Rezoning Transportation Analysis

Petition Number: 2020-012

Date	Description
02-18-2020	First Review
04-16-2020	Second Review
05-20-2020	Third Review

SHEET NUMBER
RZ-1

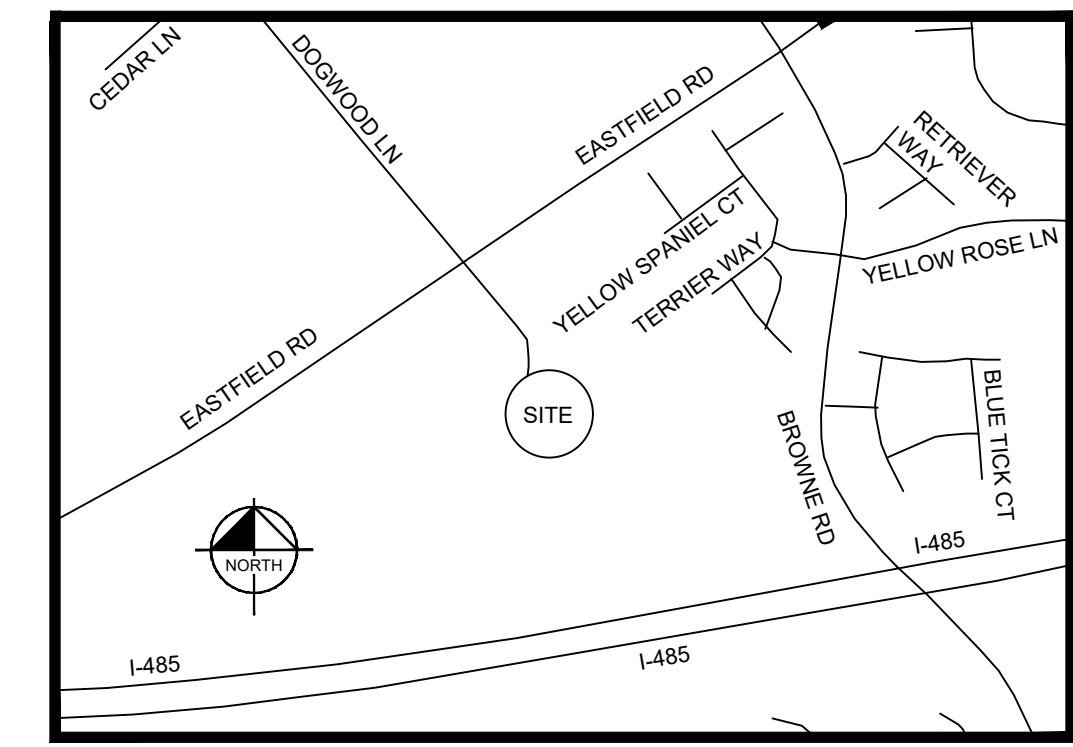
- ~~1. **Curbline** The proposed zoning district has a setback measured from back of the existing or proposed future curblines.
Eastfield Road: The future location of back of curb and gutter is 16.5' from centerline.
The site plan should show the curb and gutter labeled and dimensioned from the centerline for each road.~~

- ~~3. The petitioner should revise the site plan and conditional note(s) to commit to dedicate 35' of right-of-way from the road centerline to meet CRTPO guidelines for a minor thoroughfare. The site plan should label and dimension the right-of-way from the road centerline.~~

- ~~4. The petitioner should revise the site plan and conditional note(s) to extend road "B" to western property line.~~

- ~~5. The petitioner should revise the site plan and conditional note(s) to construct a left turn lane on Eastfield Road into Road "A".~~
- ~~6. The petitioner should revise the site plan and conditional note(s) to construct a left turn lane on Browne Road into Road "B".~~
- ~~7. CDOT is requesting the petitioner revise the site plan and conditional note(s) to create a three-lane section on Road "A" where it connects to Eastfield Road as shown below.~~
